19 February 2021

NSW Department of Planning & Environment  
GPO Box 39  
SYDNEY NSW 2001

**RE: SSD-10452 – STUBBO SOLAR FARM**

Figure 3-1 | Extent of the proposed Blue Springs Road upgrade

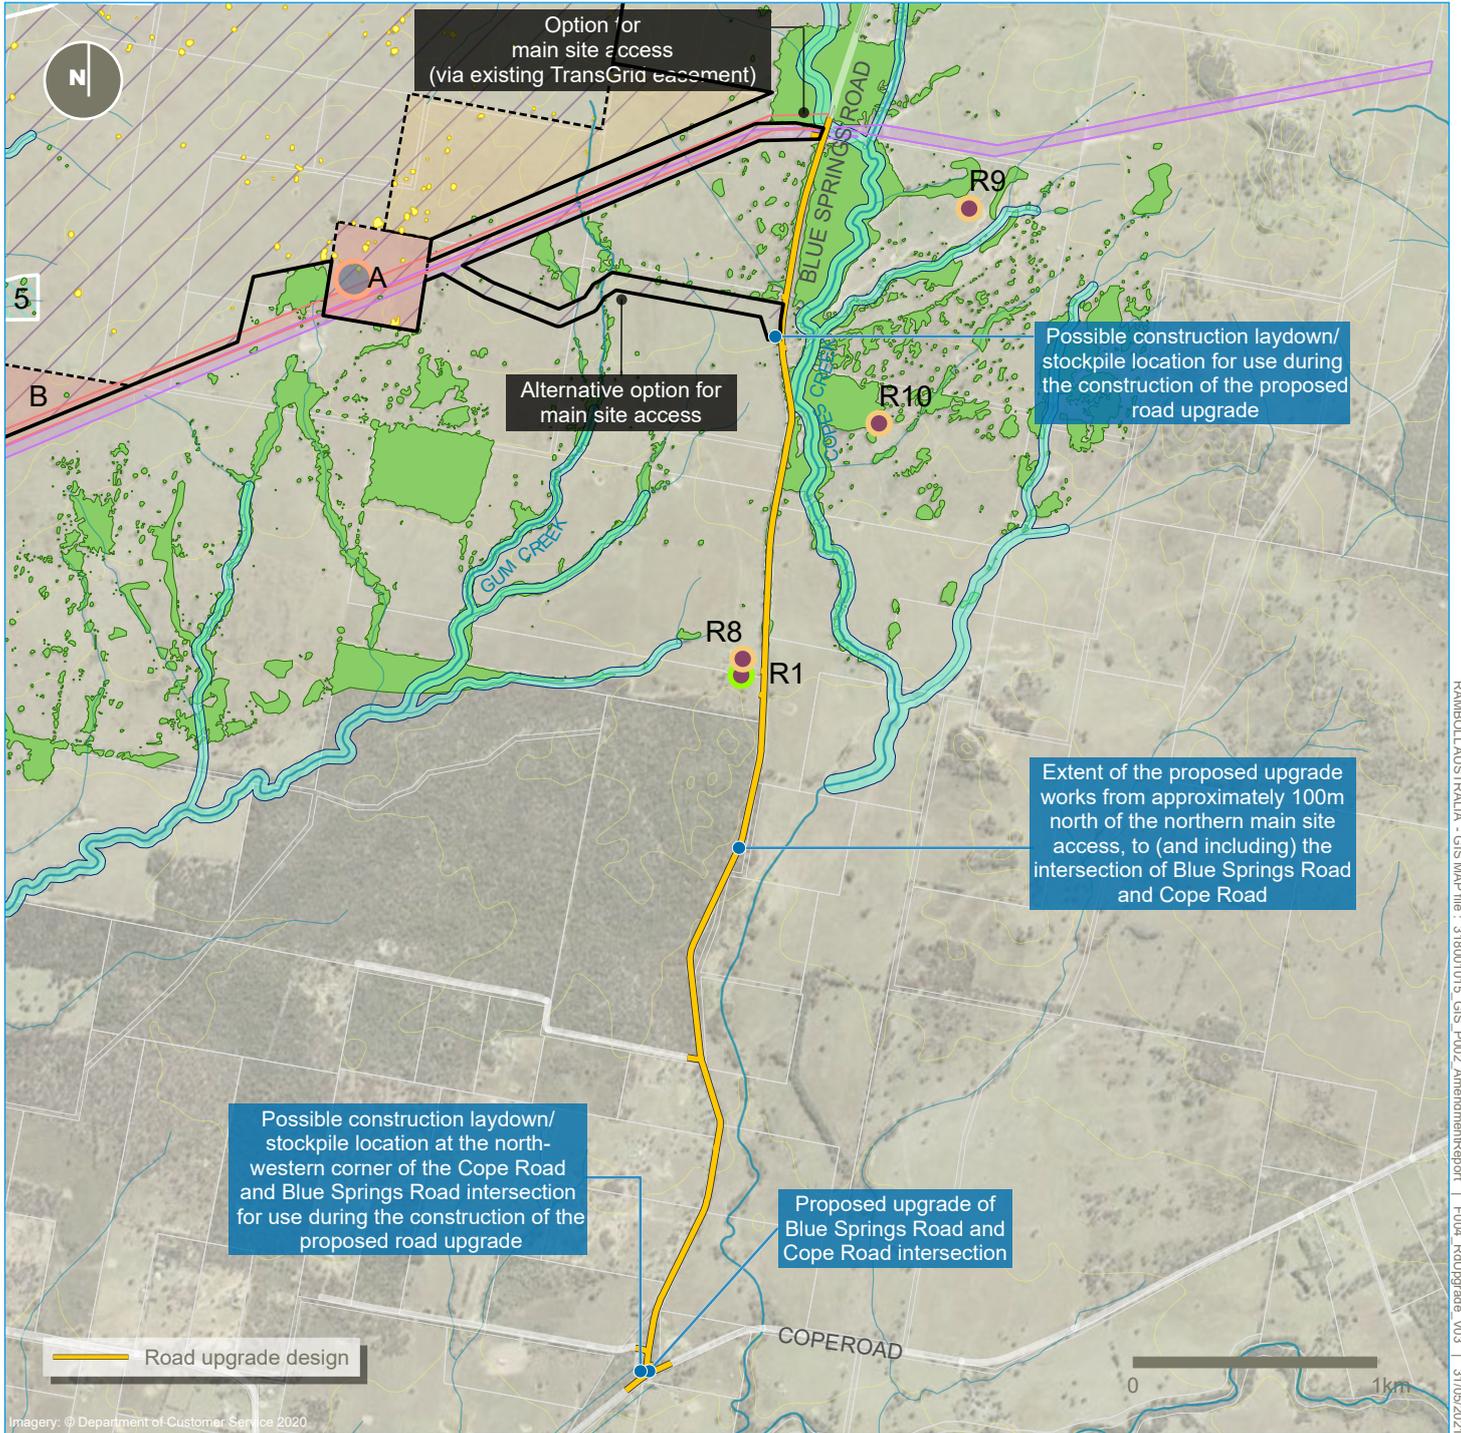
- b) Blue Springs Road from Cope Road up to and extending a minimum 100 metres beyond the Approved Access Point is required to be upgraded and widened to provide for no less than a 7 metre wide bitumen sealed pavement, with a 1 metre wide unsealed shoulder on each side.
